Application Ref:	3/2018/1014	 Ribble Valley Borough Council www.ribblevalley.gov.uk
Date Inspected:	28/01/19	
Officer:	AD	
DELEGATED ITEM FILE REPORT:

Development Description:	Listed building consent for repairs/refurbishment works and for the amelioration of the unauthorised works
Site Address/Location:	5 Gisburn Road Bolton by Bowland BB7 4NP

Drawing Title
PROPOSED GROUND FLOOR PLAN

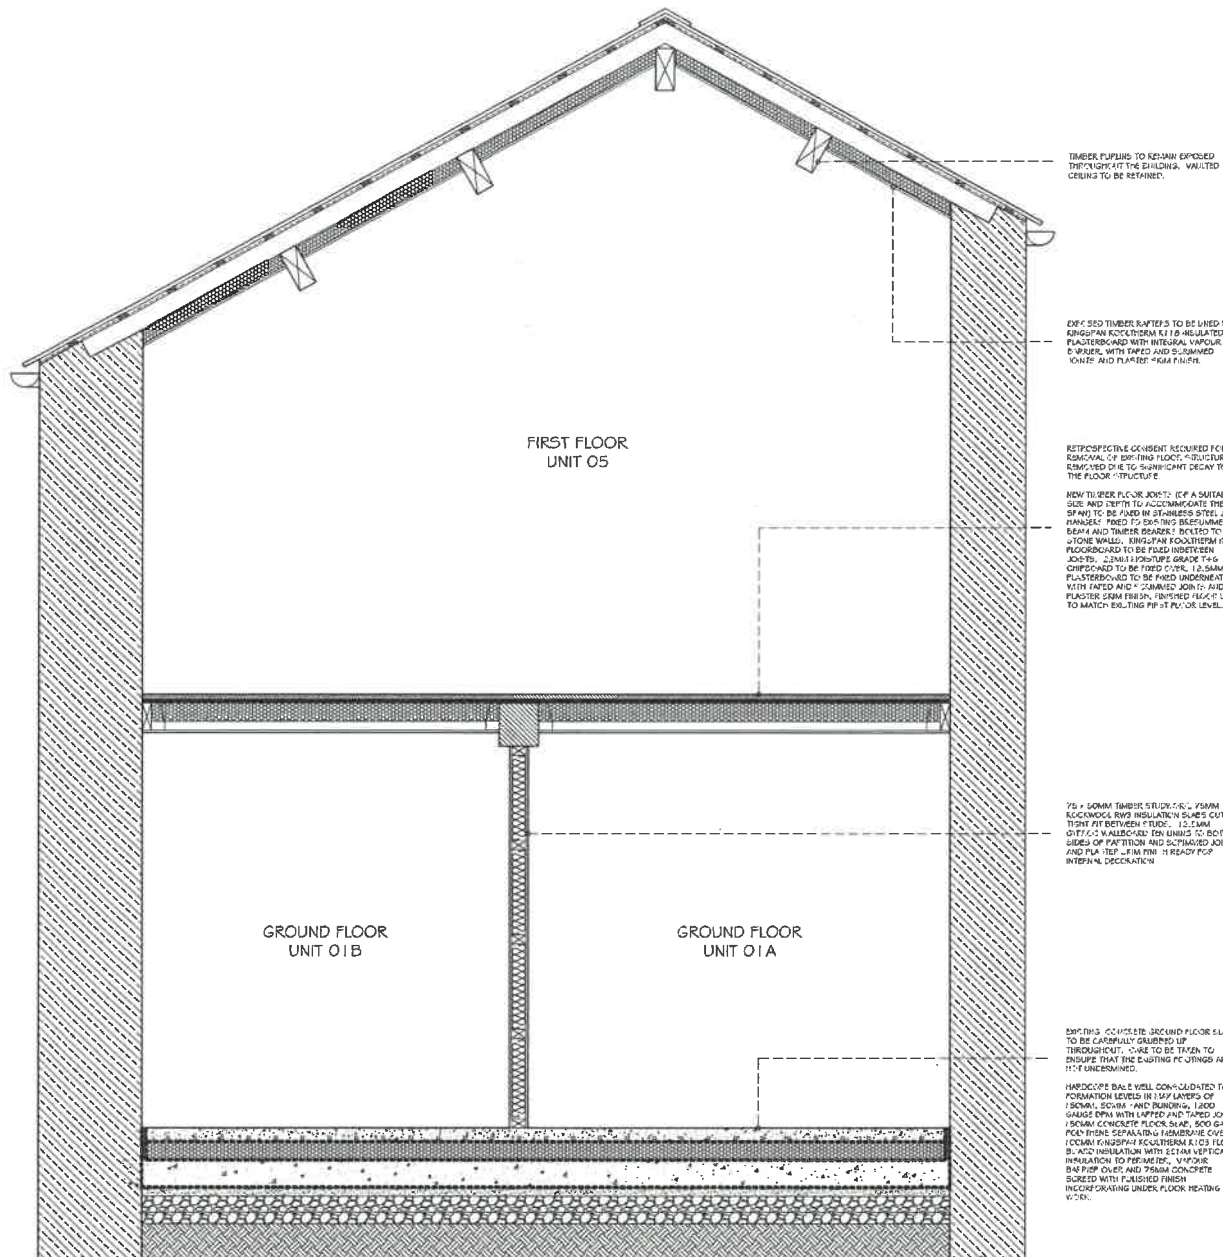
- The concrete floor is to be retained with only the highest areas being reduced in height in order to provide a level floor. A self-levelling compound will also be laid over the top of the concrete floor. This would cause the least amount of harm than having to remove the entire floor to put in a new floor as this is the least invasive

- The existing tanking slurry that has been applied to the ground floor walls is removed (by hand) where possible and that the affected areas are repointed as per the provided re-pointing method statement and specification in order to maintain breathability of the wall fabric”.

- The external walls are to be re-pointed with lime
- The concrete floor is to be retained with only the highest areas being reduced in height in order to provide a level floor. A self-levelling compound will also be laid over the top of the concrete floor.

- The existing tanking slurry that has been applied to the ground floor walls is removed (by hand) and the affected areas are repointed as per the provided re-pointing method statement and specification set out on the approved plans.

PROPOSED FIRST FLOOR PLAN AND

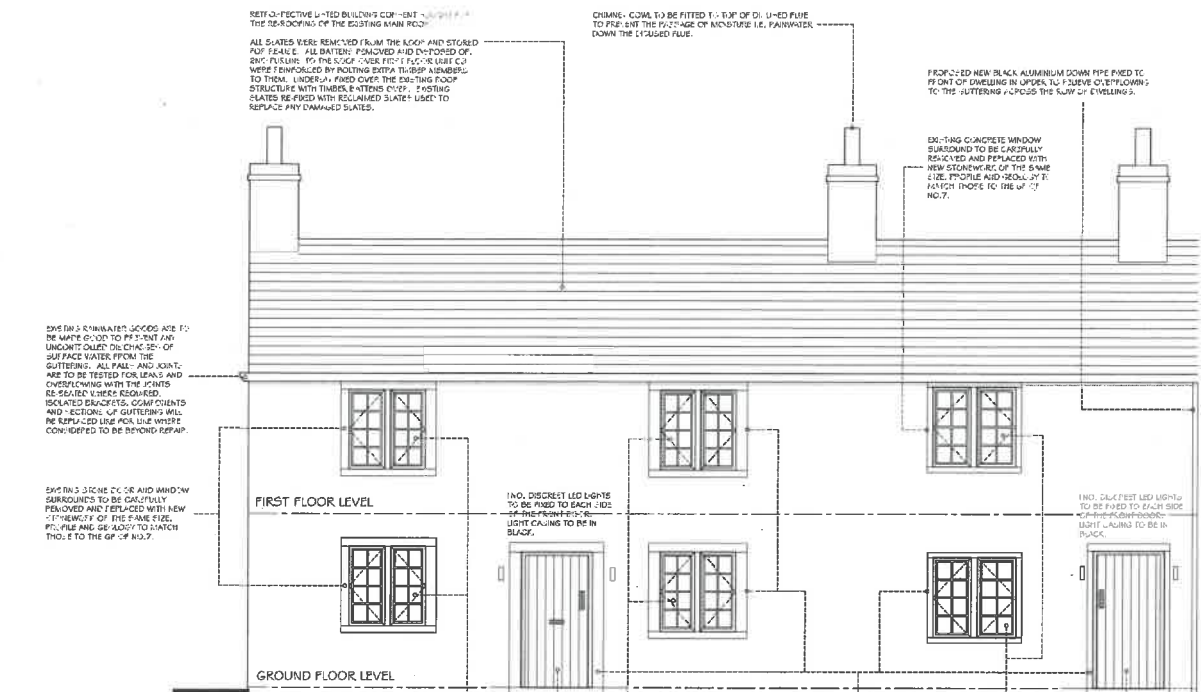
- Insufficient information (re: historic fabric removal) has been submitted to grant listed building consent 'retrospectively' for the implemented works;
- Not all work appears to be authentic replacement or repair (lath and plaster partition walls and ceilings; location of ceilings; re-plastering of all walls; First Flooring in Unit 05; retention of replacement uPVC roof light);
- Little information has been submitted to describe or justify the proposed removal of existing (mainly front elevation) windows and replace with modern double-glazed side-opening casement;
- The proposal to replace all of the stone surrounds to windows and doors at the front elevation
- The proposal to remove the existing concrete flooring is an opportunity to consider sympathetic floor replacement;
- New painting of timber beams and joists

- Bathroom floor / first floor unit 5 - Will be reinstated in the same position at 2017 (like-for-like position).
- First floor ceilings – Most of the first floor rooms originally had skelings of varying heights. As the ceilings originally showed part of the roof pitch I am proposing ceilings are reinstated as fully vaulted ceilings- The variation will utilise what was a very small unusable space above the bedrooms and create a more airy and spacious living space. Previously hidden qualities of the historic building, beams and purlins, will be visible and add to the experience of the building. As proposed, importantly the whole of the roof can be insulated increasing the buildings thermal efficiency. All enhancing the enjoyment and comfort of the building.

The proposed vaulted ceilings would expose elements of the roof structure and whilst this is not a typical feature of the Georgian property would show the evolution of the building and does not hinder the ability for such features to be reinstated in the future. In this case the works as proposed are considered to be acceptable and will enable the property to be brought back into use as a dwelling.

Drawing Title
PROPOSED ELEVATIONS

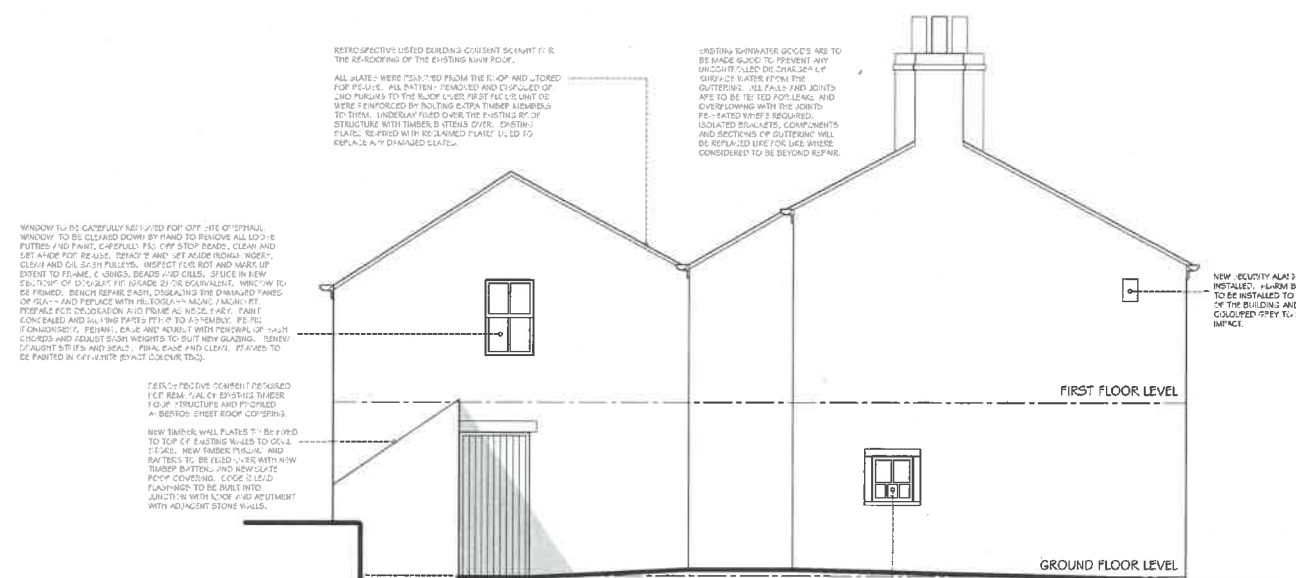
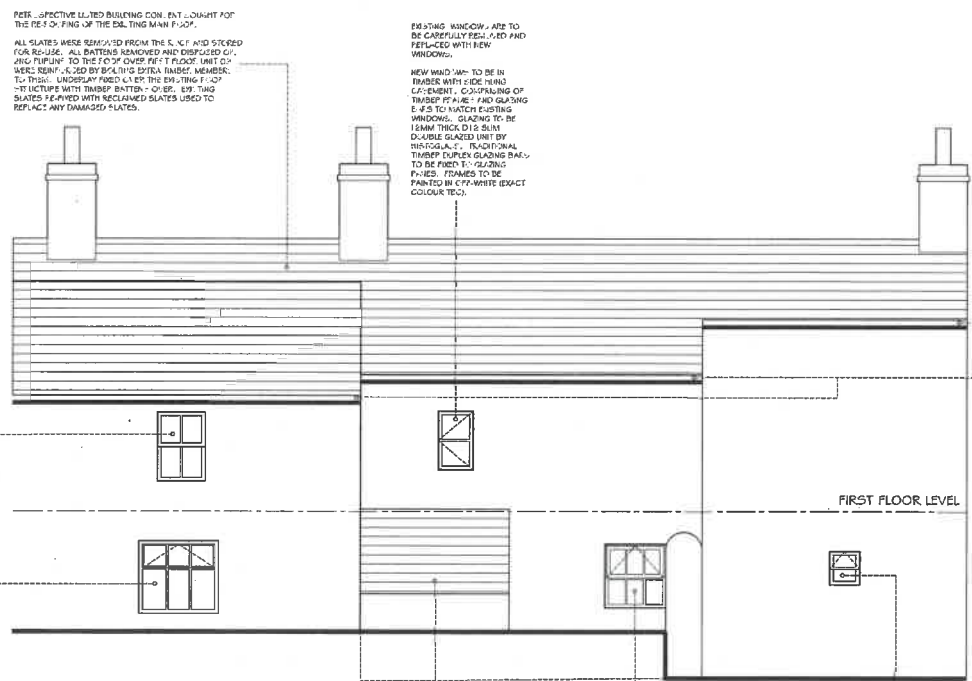
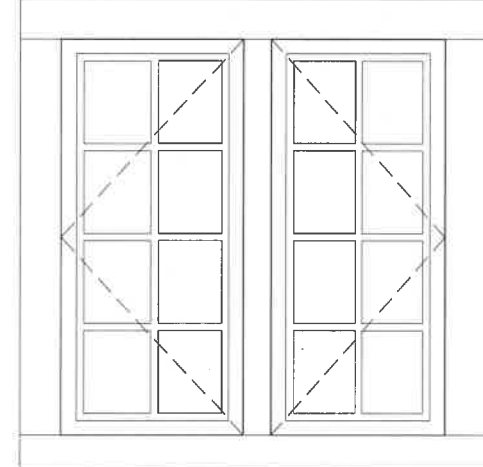
- The existing windows proposed for replacement are a modern intervention and are of poor quality and crudely made ...intention of the applicant to install new timber windows of similar appearance and with new single glazing ... The ground floor window to the east facing elevation has been amended and will be a fixed window as a per existing

- Stone surrounds are significantly decayed and we now proposed that only the most decayed stone surrounds and mullions are to be removed and replaced as well as the reinstatement of two mullions which have previously been removed. This is the most essential work regarding the stone surrounds. This will constitute minimal intervention and the replacement of elements which are beyond repair.

The above amendments/ confirmation addressed the majority of the concerns however the following concerns/ omissions were requested from the applicant on 11th March:

- 1) plans detailing the proposed roof light
- 2) details of the original (or historic) surface finish of the ceiling timbers
- 3) justification for not replacing floors, walls and ceilings in their pre-unauthorised works form and materials.

- 1) Proposed roof light: Velux conservation style External finish: dark grey RAL 7043
 - Internal: Pine with white paint finish
 - Fit: recessed flashing
 - Opening style: GGL
 - Dimensions: W:550 x H:780mm
- 2) Surface finish of the ceiling timbers: will leave timbers as they are to degrade.
- 3) Justification for not replacing floors, walls and ceilings in their pre-unauthorised works form and materials:
 - Propose to reinstate the walls and bathroom floor (first floor unit 5) as they were located when the house was purchased in 2017. No alteration to plan form.
 - The majority of repairs internally and externally are to be carried out with the sensitive use of materials akin to the historic nature of the building. More modern alternatives have been suggested where it is felt the building could be misread in the future, impact is low/nil and all are reversible.

- The ground floor window to the east facing elevation will be a fixed window as per existing.
- Only the most decayed stone surrounds and mullions are to be removed and replaced as well as the reinstatement of two mullions which have previously been removed. This shall be in accordance with the submitted Stone Masons report apart from the suggested use of a stone sealant and the approved plans.
